State of Washington
DEPARTMENT OF FISH AND WILDLIFE

July 18, 2024

SUBJECT: WDFW COMMENTS ON SE-24-00021 JOHNSON AG UTILITY BUILDING

Critical Areas Map

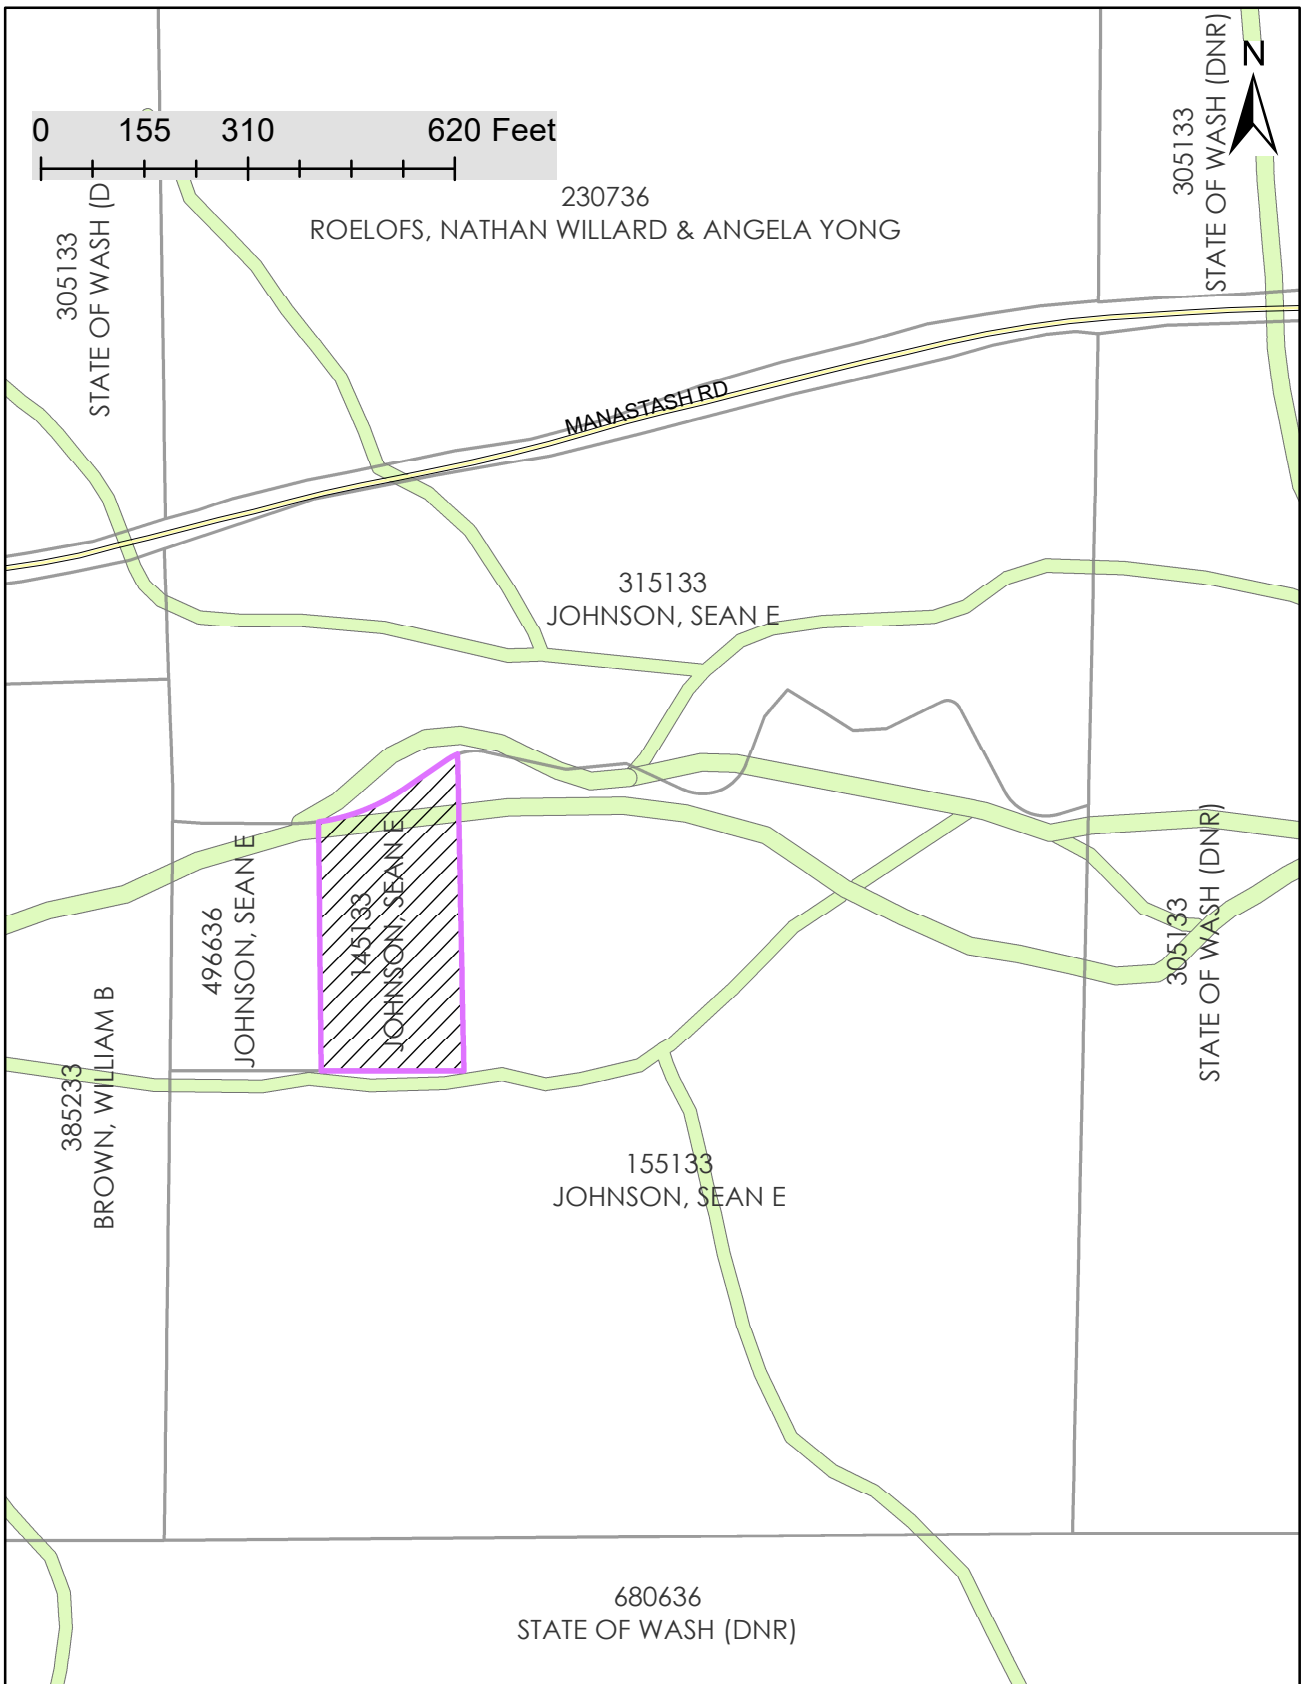
WDFW appreciates the efforts that have already occurred to identify the Geologically Hazardous Areas (GHA) such as the Channel Migration Zone and steep slopes. We did not see information provided about frequently flooded areas or other critical areas such as Critical Aquifer Recharge Areas, Wetlands, or Fish and Wildlife Habitat Conservation Areas (FWHCA). We would welcome the opportunity to have a site visit with the applicants and/or County to better understand the potential risks or benefits to all critical areas, particularly the FWHCAs.

Hazardous Slopes Map

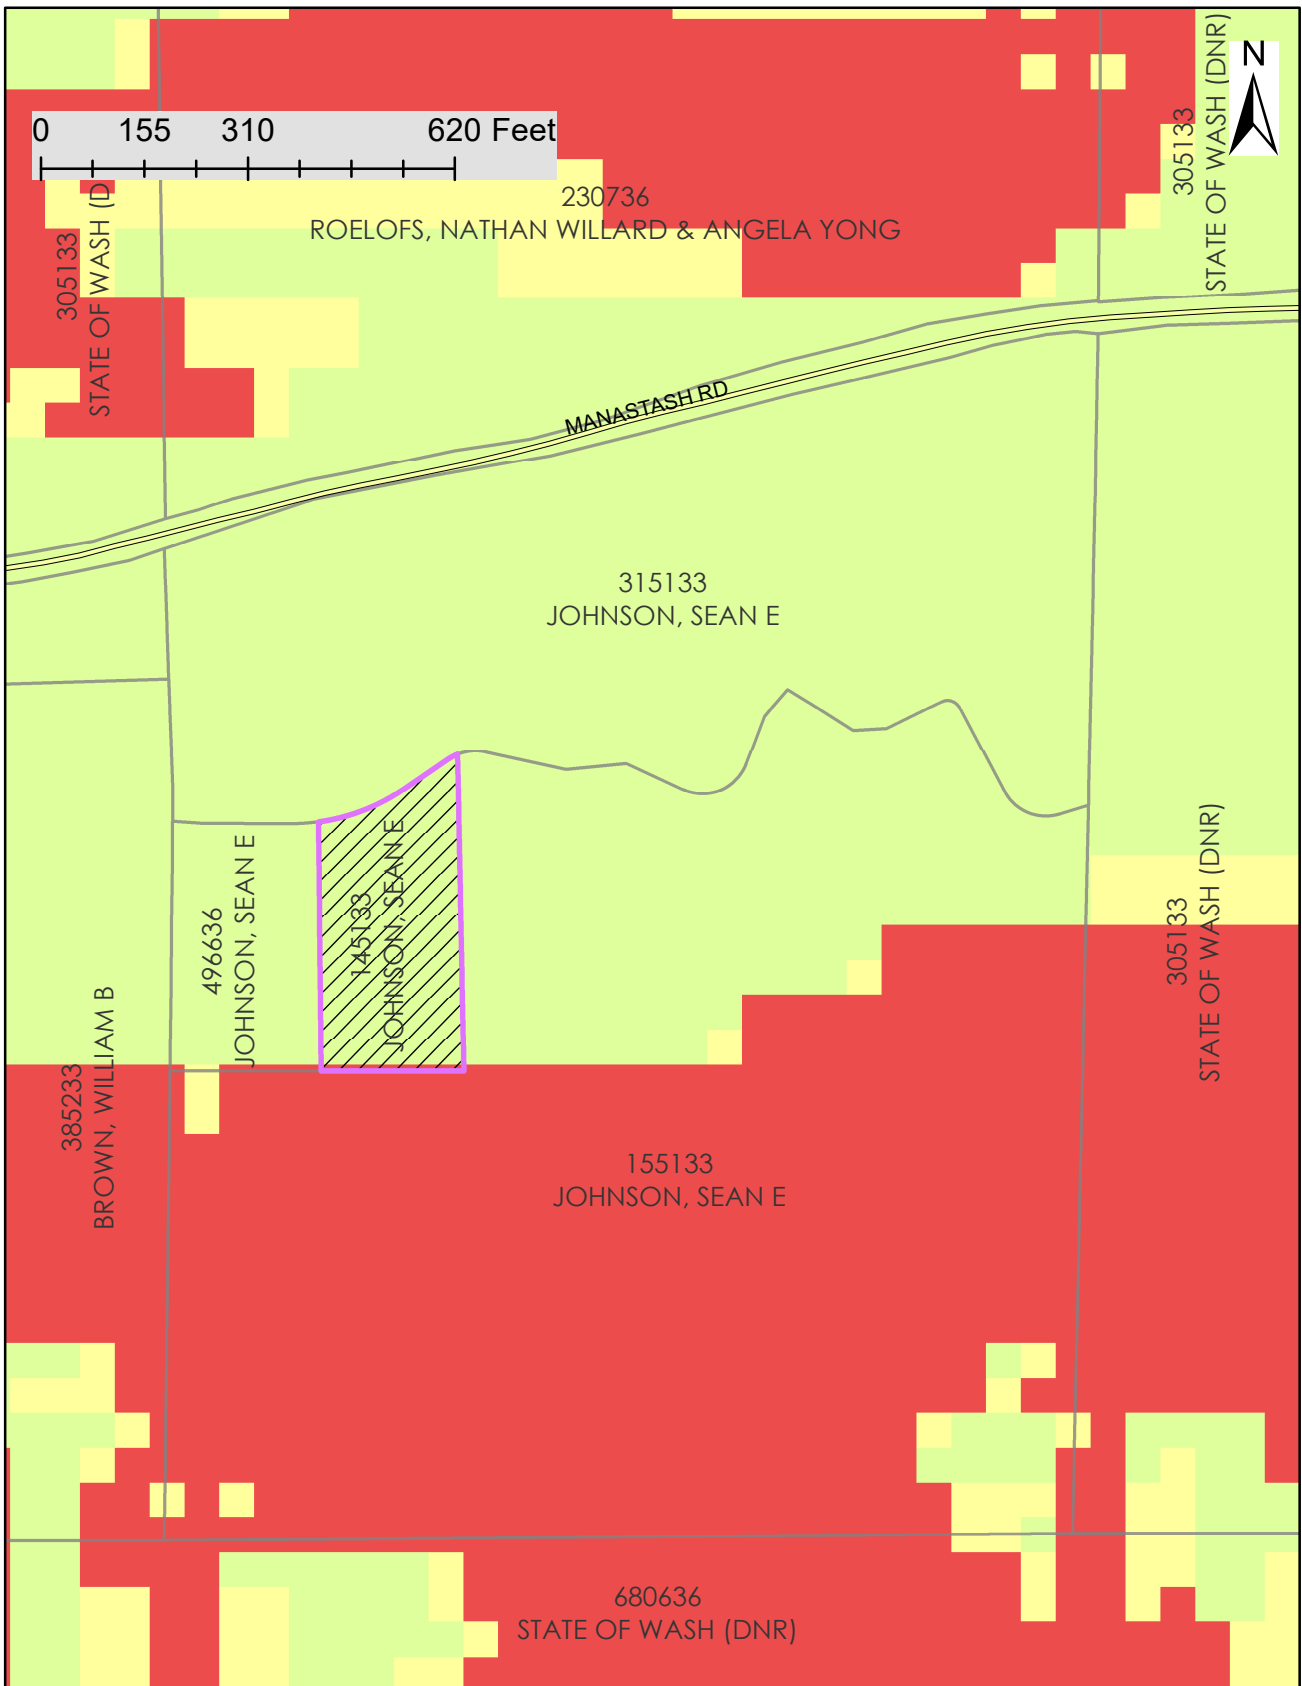
Some of the photos and information provided show that there are talus slopes and/or cliffs present near the proposed building site. Talus slopes and cliffs are priority habitats within WDFW's Priority Habitats and Species (PHS) program and warrant further consideration for how they will be protected and/or mitigated for with construction of the building that appears to be cut into the slope. This parcel and surrounding properties are also recognized as important mule deer winter range, another PHS listing. WDFW requests that all critical areas in the project area be identified and evaluated for the need for a habitat management and/or habitat mitigation plan.
